**Lead Local Flood Authority**  
**Post Point CHN 215**  
**Hertfordshire County Council**  
**County Hall, Pegs Lane**  
**HERTFORD SG13 8DN**

Date 23 February 2023

**RE: 6/2022/2801/MAJ Campus East Car park College Way, Welwyn Garden City, AL8 6DG**

We **object** to this planning application in the absence of an acceptable Flood Risk Assessment (FRA) as.

Title
FLAT BLOCKS B3 & B4
LEVELS 0, 1 & 2
PRIVATE + S/O B3 GF & B4 GF

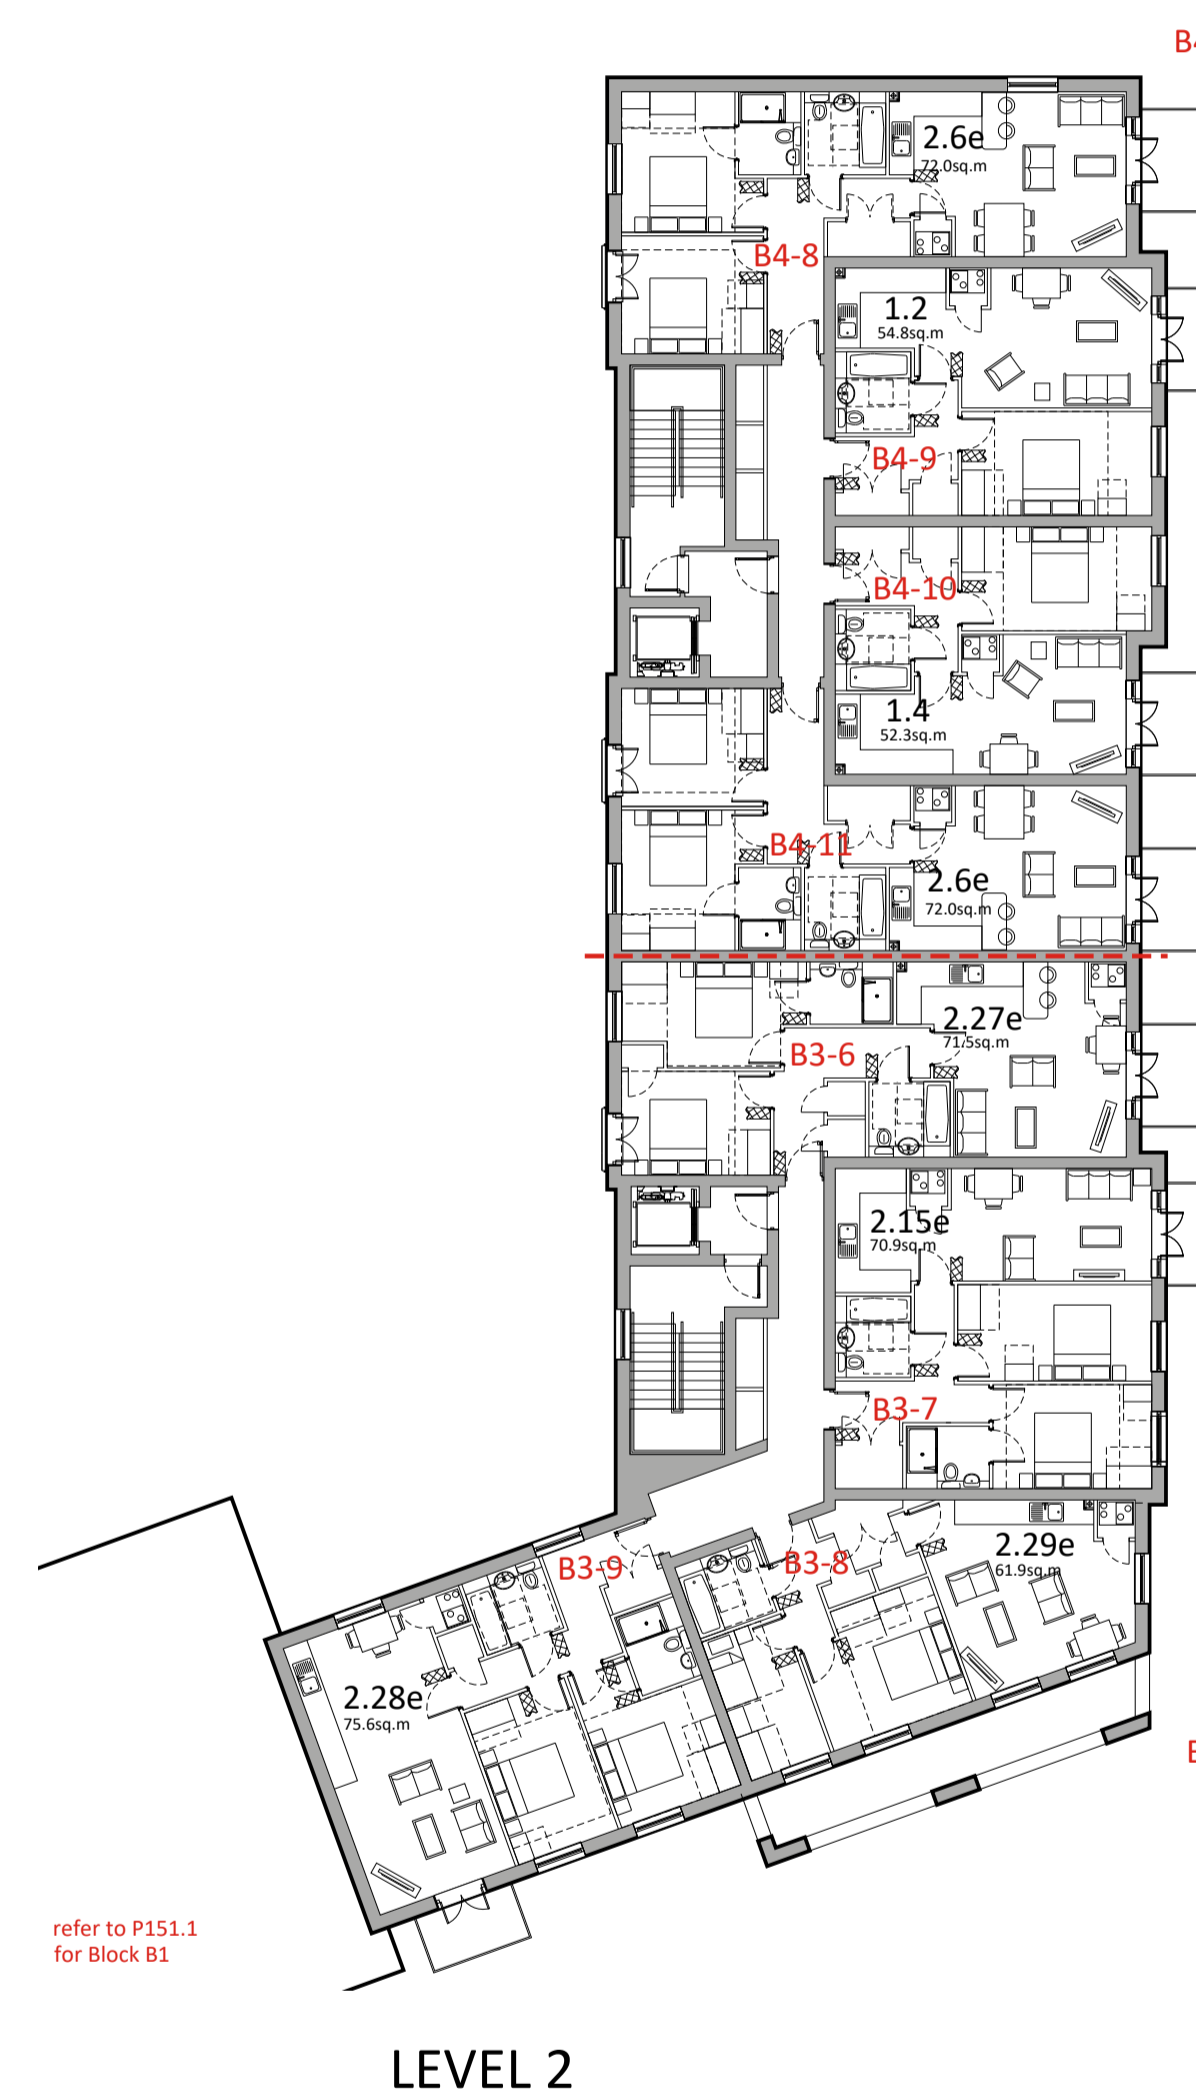
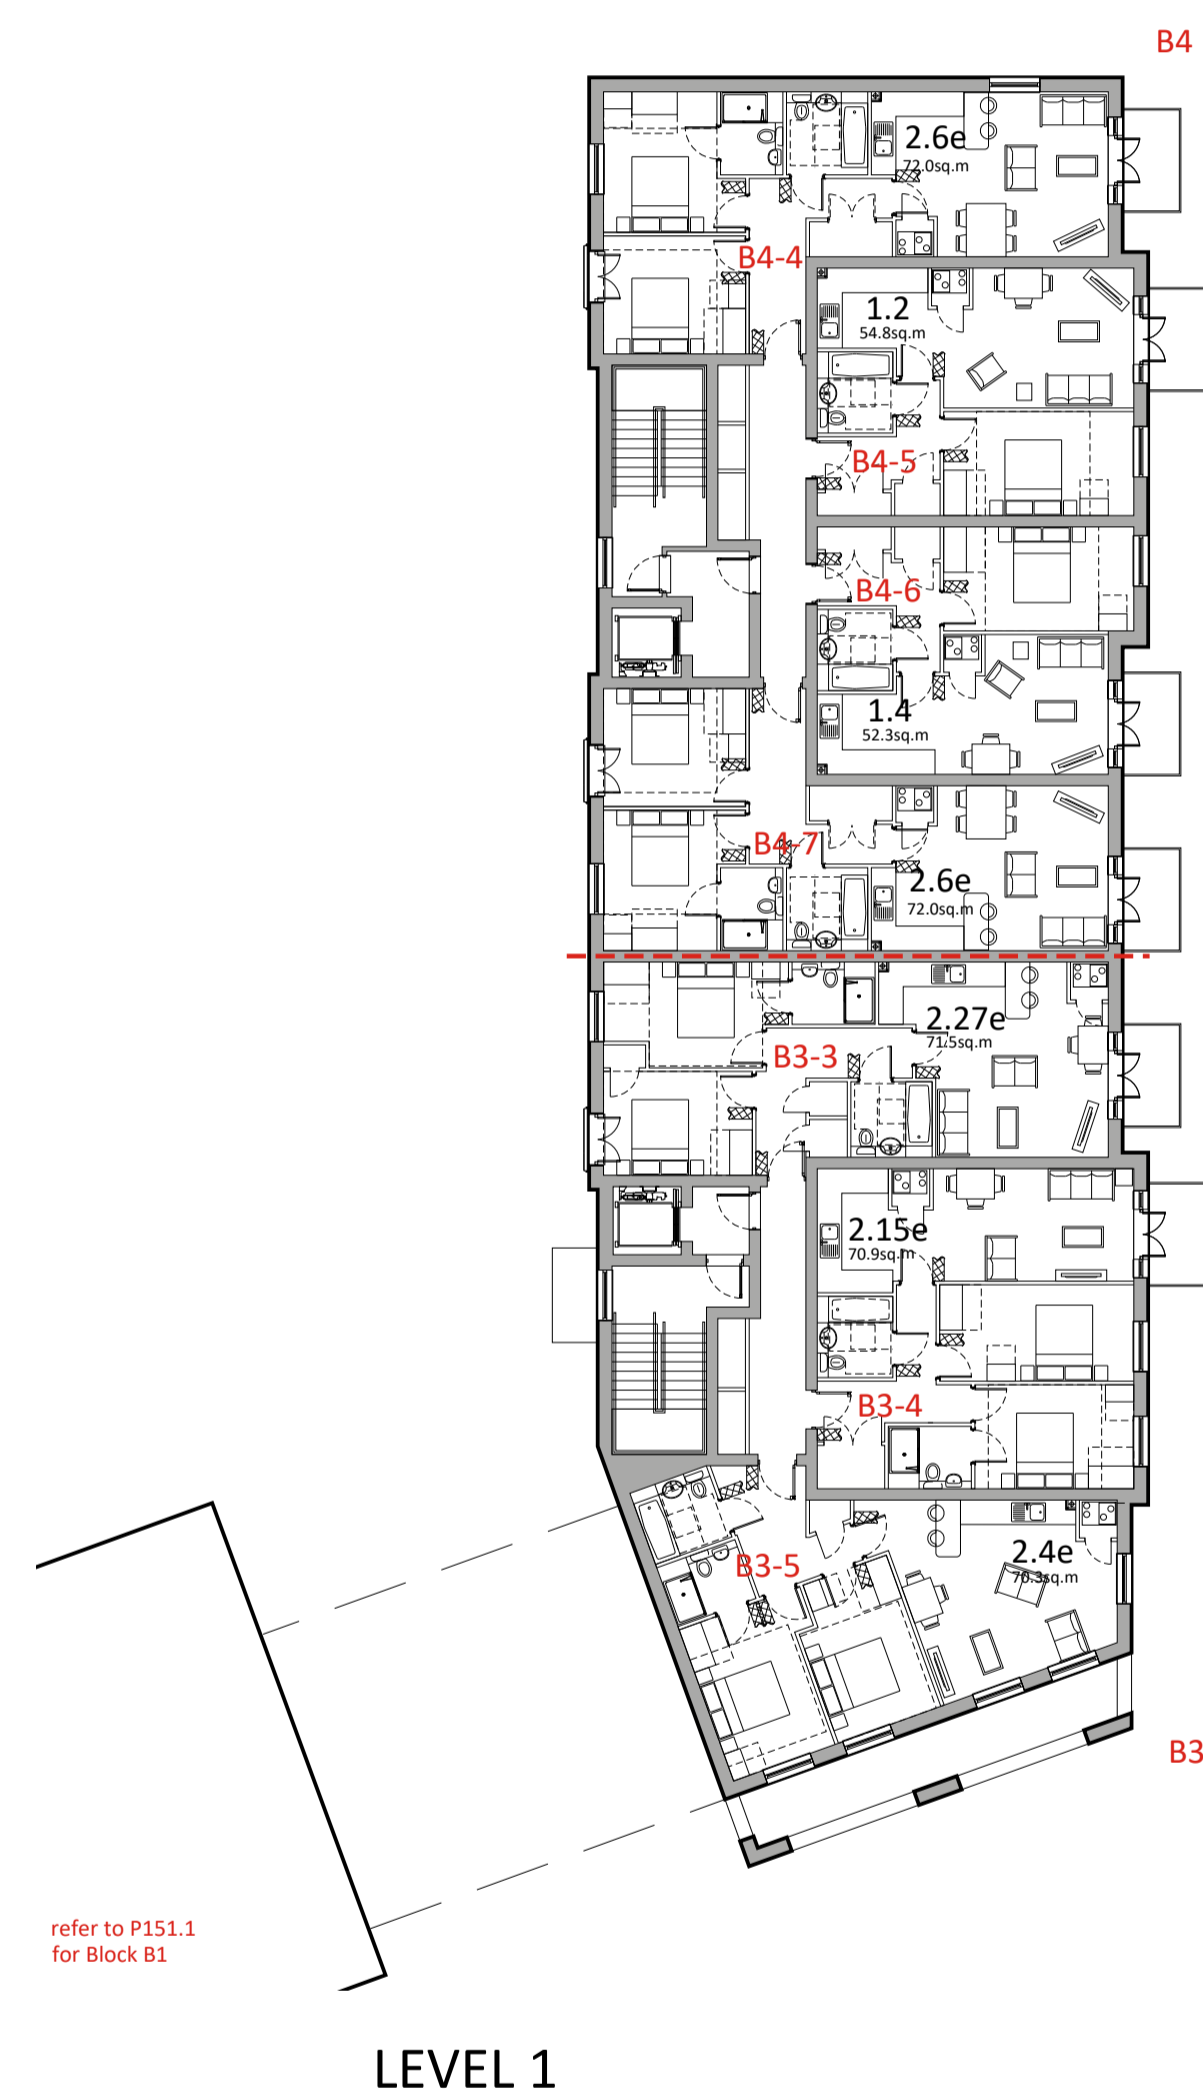
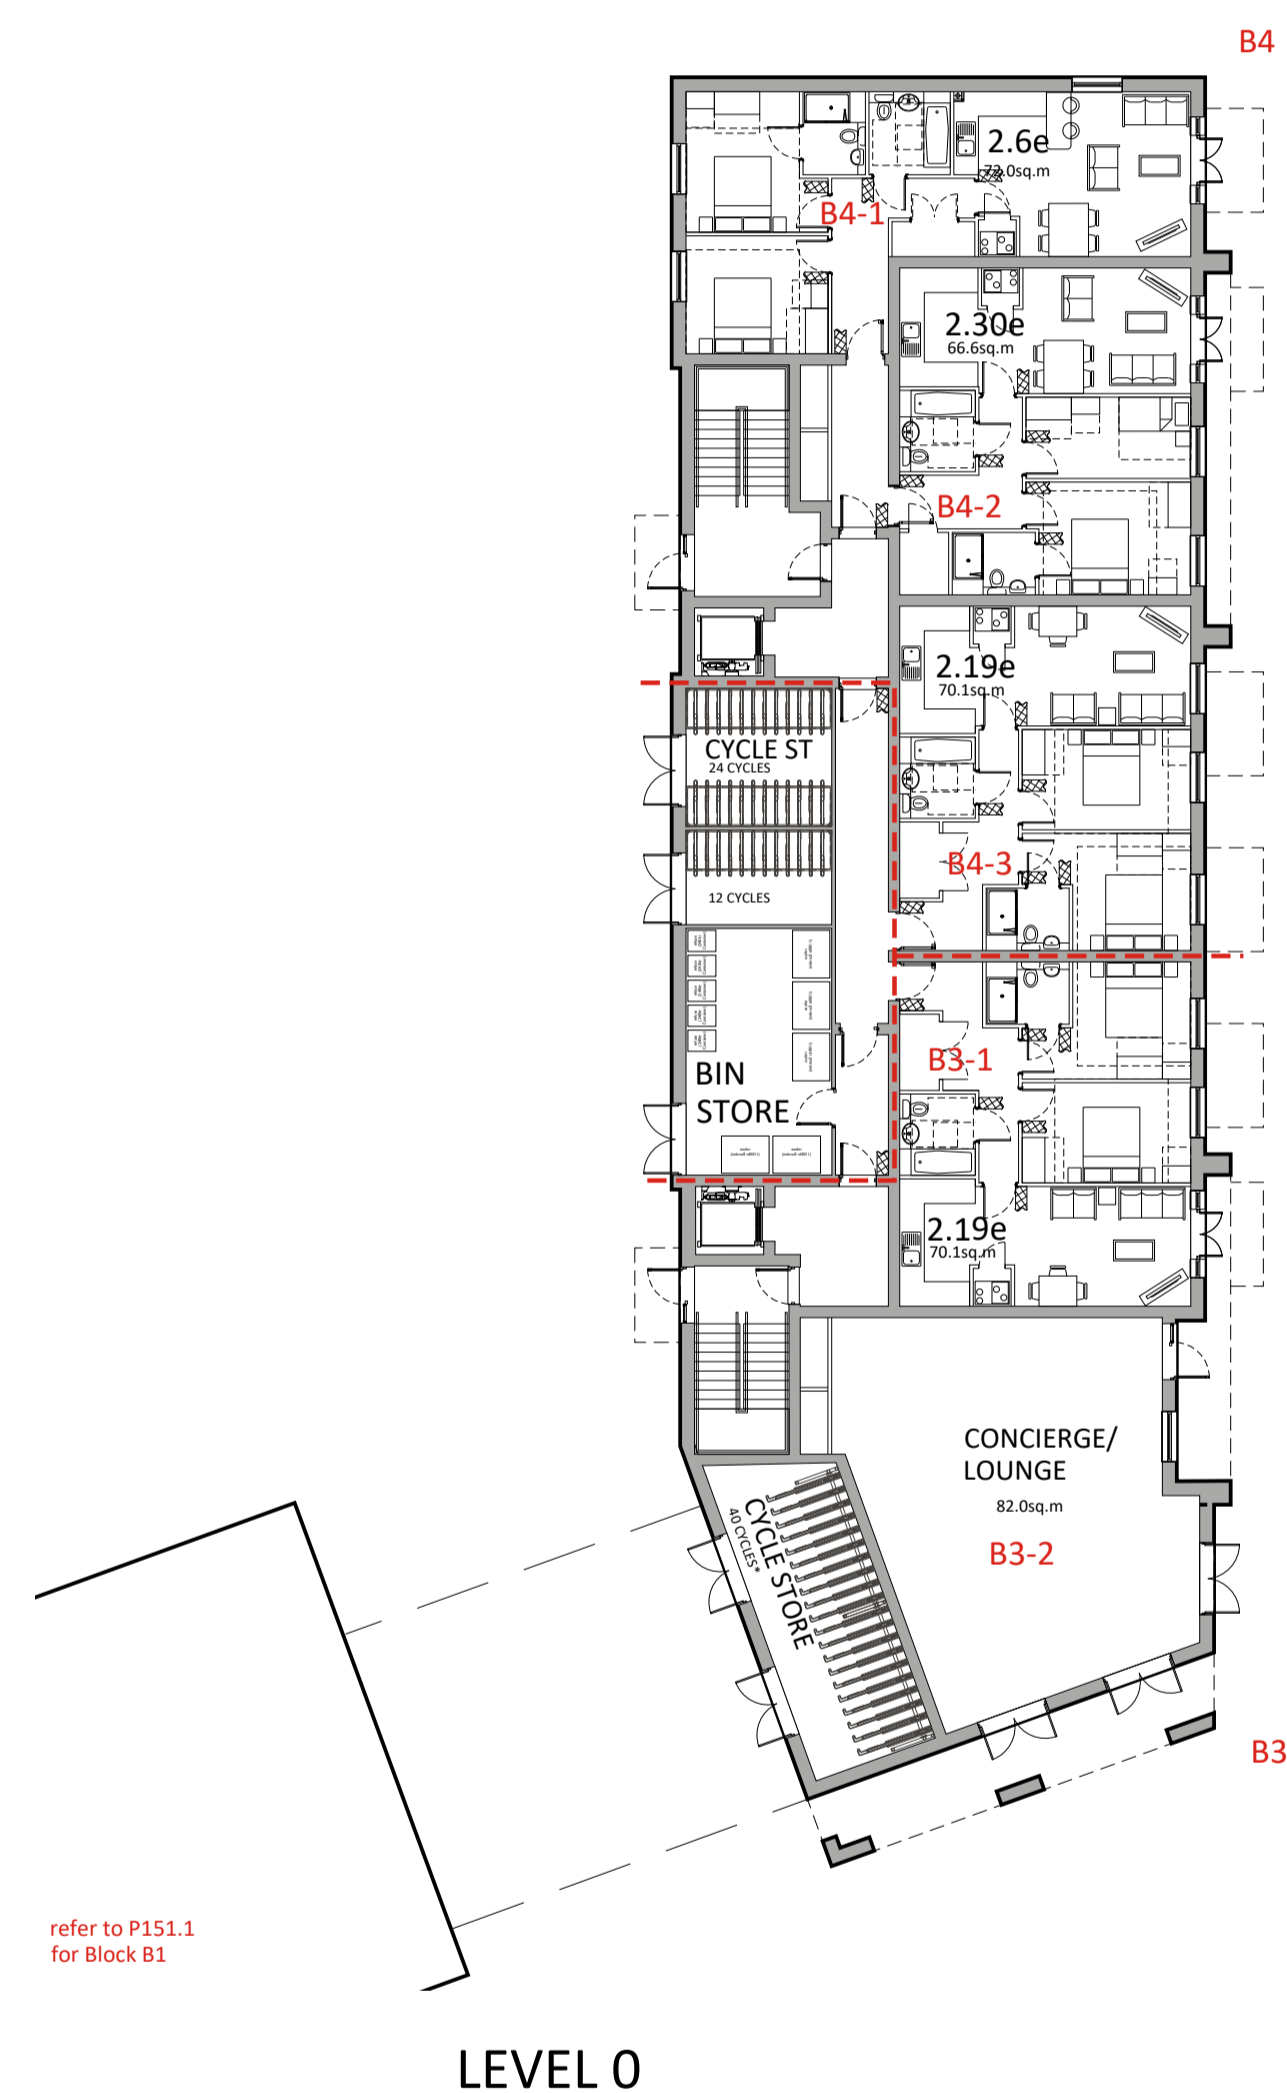
3. The site is indicated as being at medium to high risk of surface water flooding (as indicated by the Environment Agency Surface Water Flood Risk Map) and the submitted Flood Risk Assessment (FRA). An ordinary watercourse is present on the northern boundary of the site. A surface water flow path passes through the site, flowing south towards bridge road (South of the site). The surface water flow path will impact blocks B3, A2 and A3.
